REF: N164621

DATE: 31 March 2020

RE: SSD 9813 - 136-146 AND 148 DONNISON STREET, GOSFORD (GOSFORD ALIVE) – RESPONSE TO STAKHOLDER SUBMISSIONS

LANDSCAPE MASTER PLAN

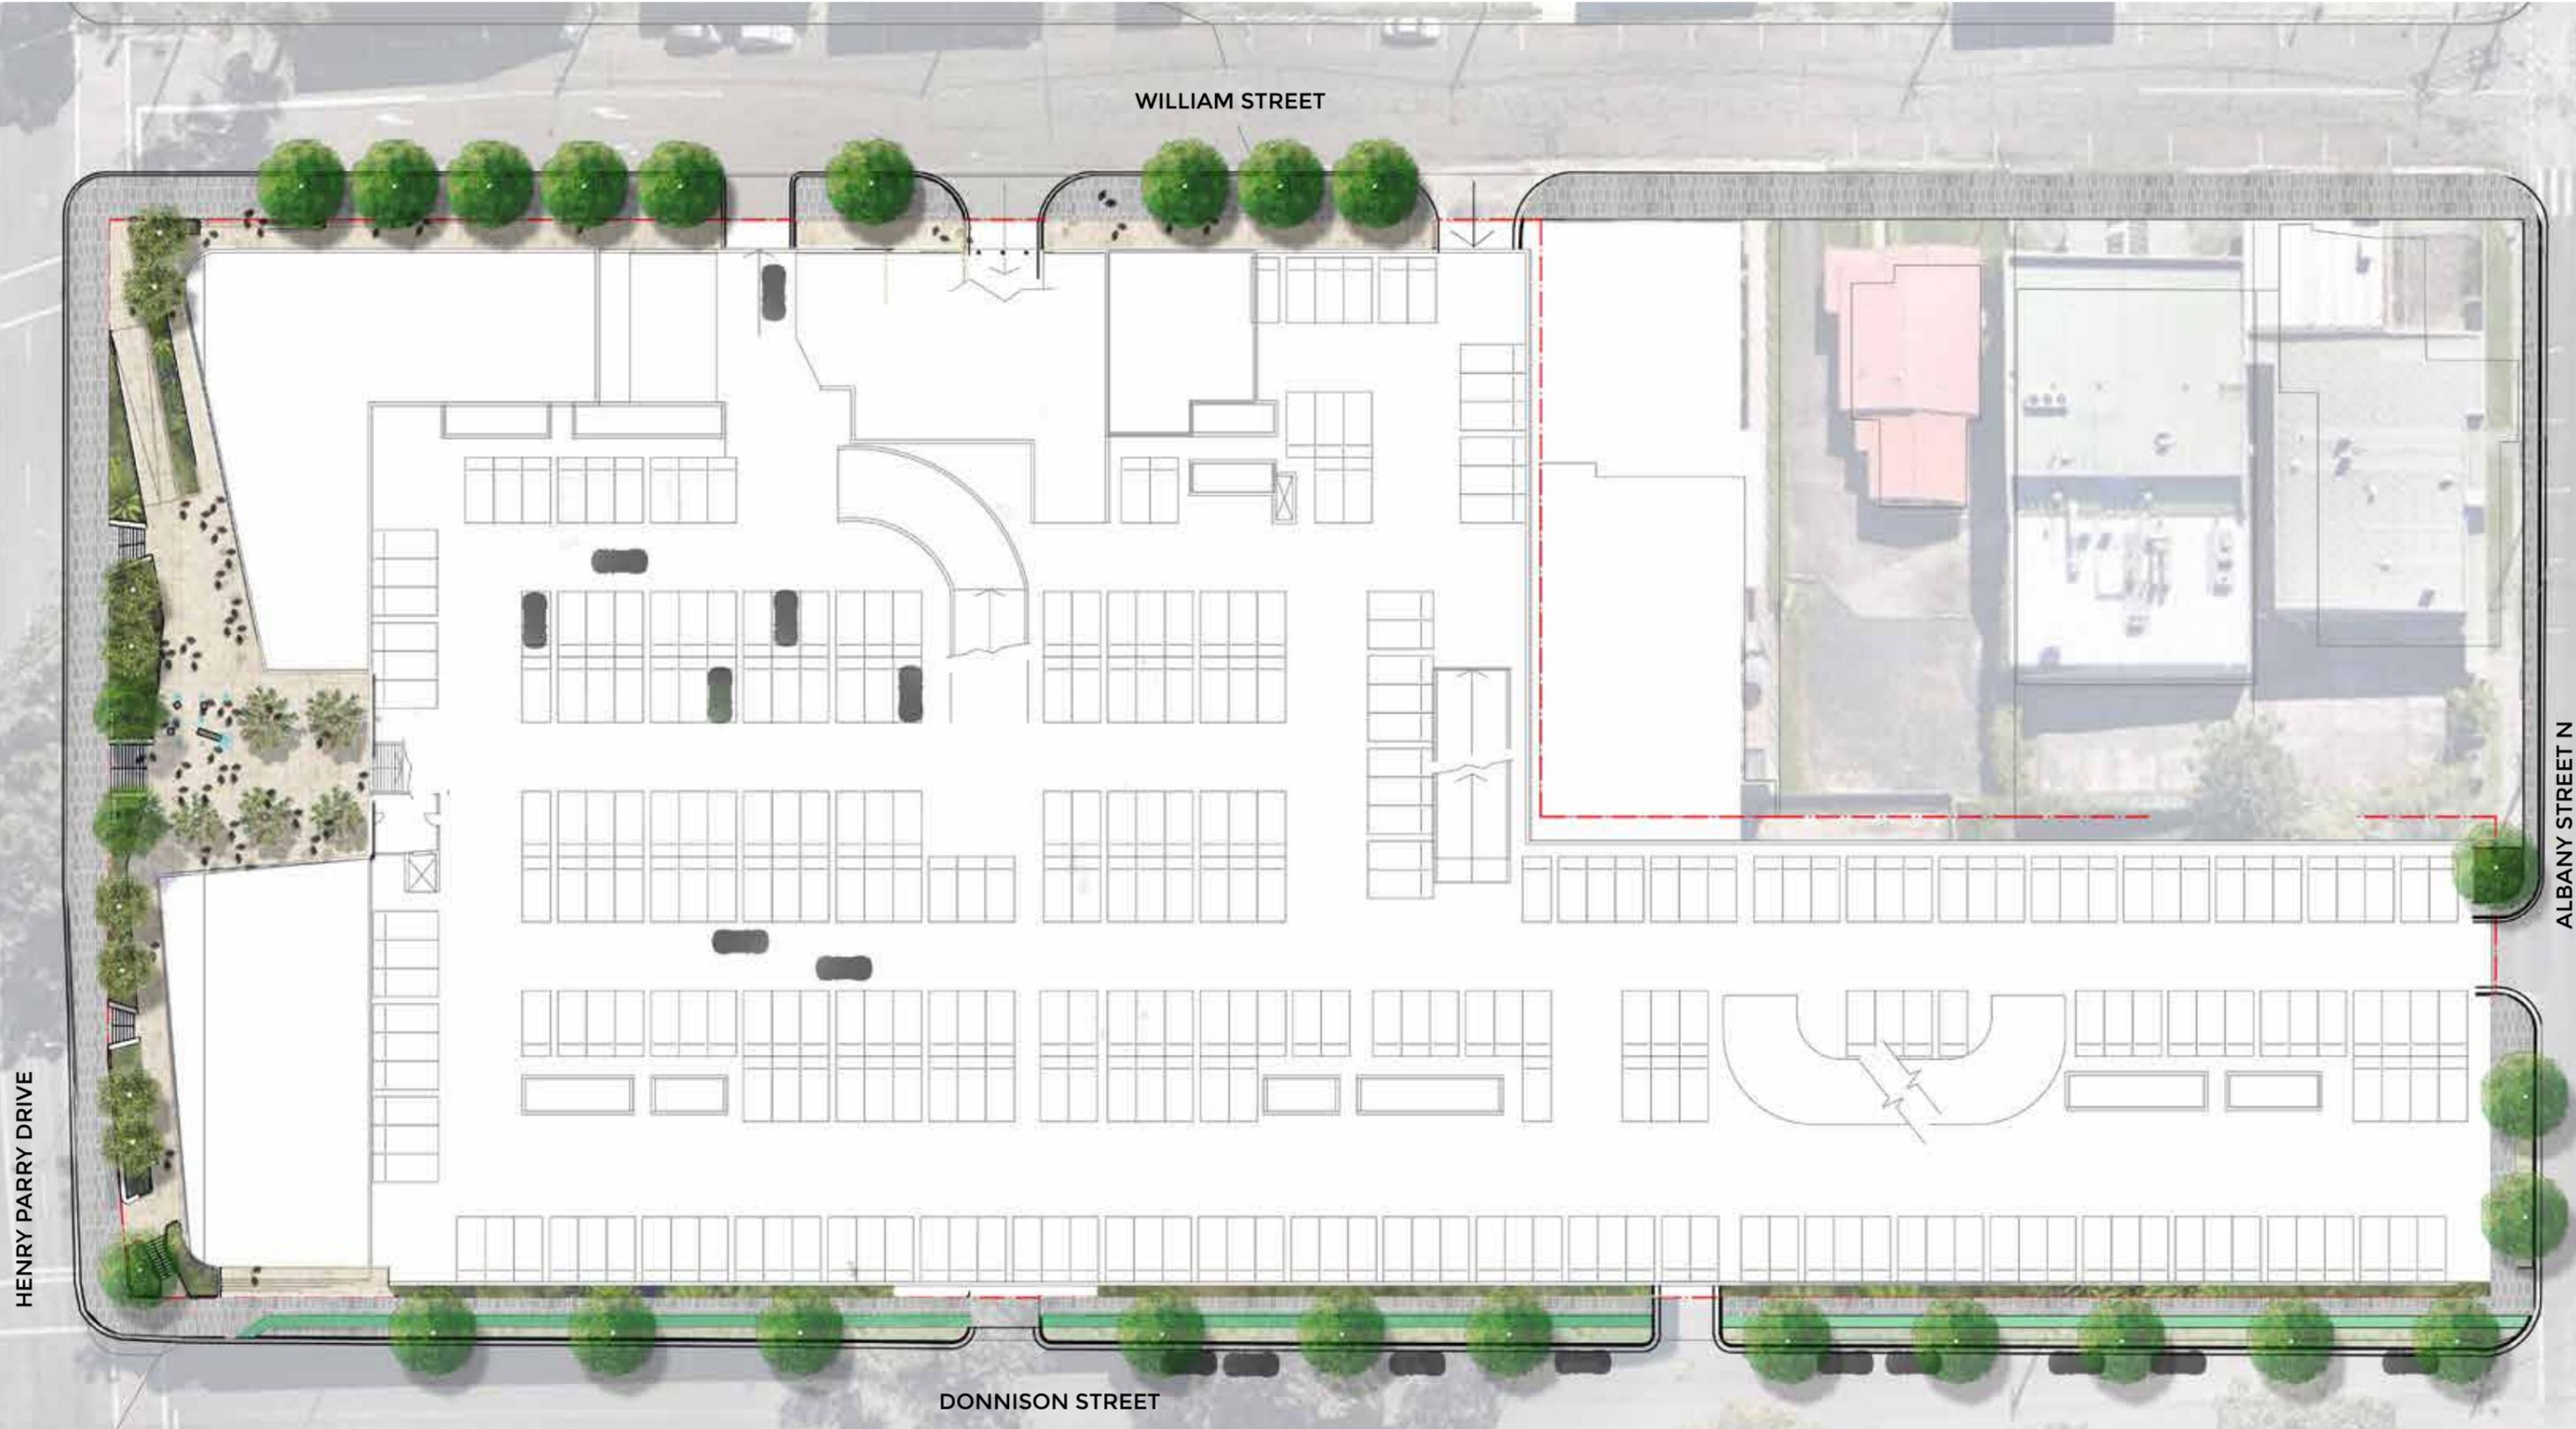
A landscaped median approximately 1.2m wide is proposed within William Street on the centreline of the road across the frontage of 'Tower 1'.

This landscaped median is not supported...

The architectural and landscape plans will be updated to remove the landscaped median.

Narrowing of the road pavement in Henry Parry Drive from the existing 13m-14m width to a total width of 12m (as per the section of Henry Parry Drive on the Landscape Masterplan).

This is not supported...

This comment is noted. The architectural and landscape plans do not propose any modifications to the road pavement along Henry Parry Drive.
